Application for a non-material amendment following a grant of planning permission.

<input type="text" value="Proposed Two Storey Rear Extension"/>	
Reference number:	<input type="text" value="20/01661/HOU"/>
Date of decision	<input type="text" value="25/03/2021"/>

Reconfiguration of window apertures to East Elevation  
Inclusion of Flue  
Removal of Render material and replacement with facing brickwork at Lower Ground Floor Level

2487-EA-00-00-DR-A-107-B2 - PROPOSED ELEVATIONS

**1 East Elevation - Proposed**  
1 : 50

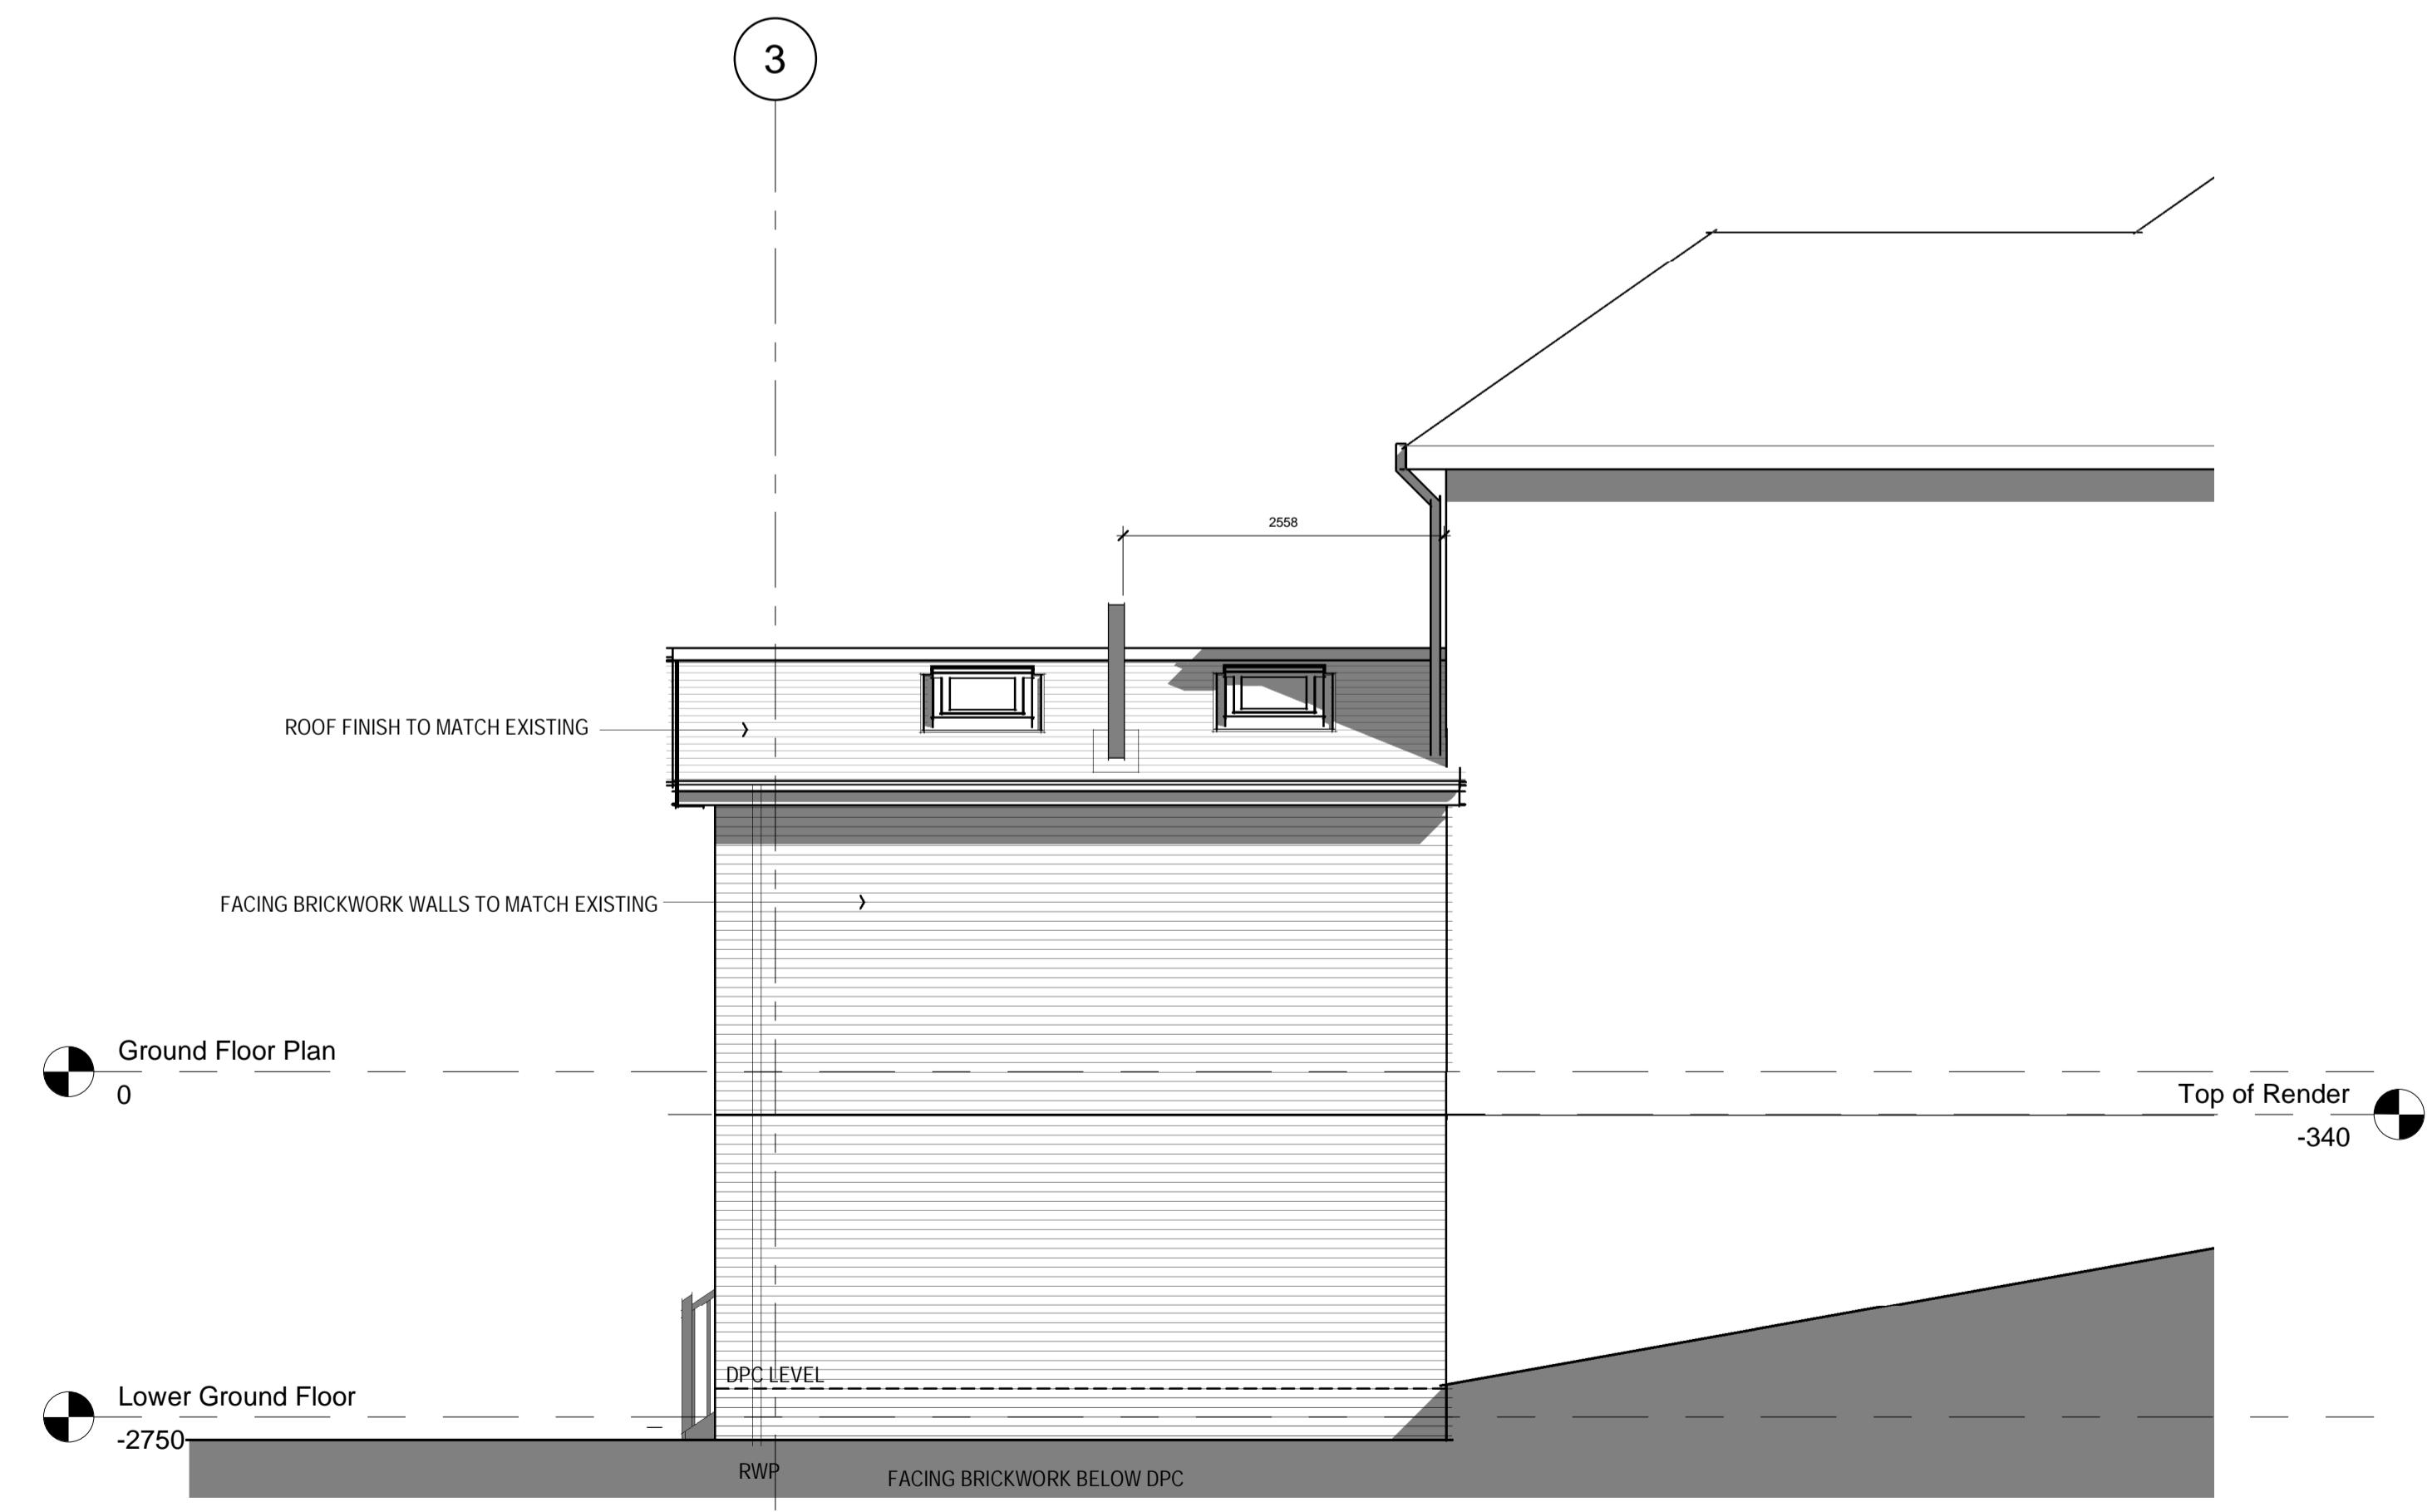
Client wishes to have different window apertures.  
Facing brickwork is a more robust material solution
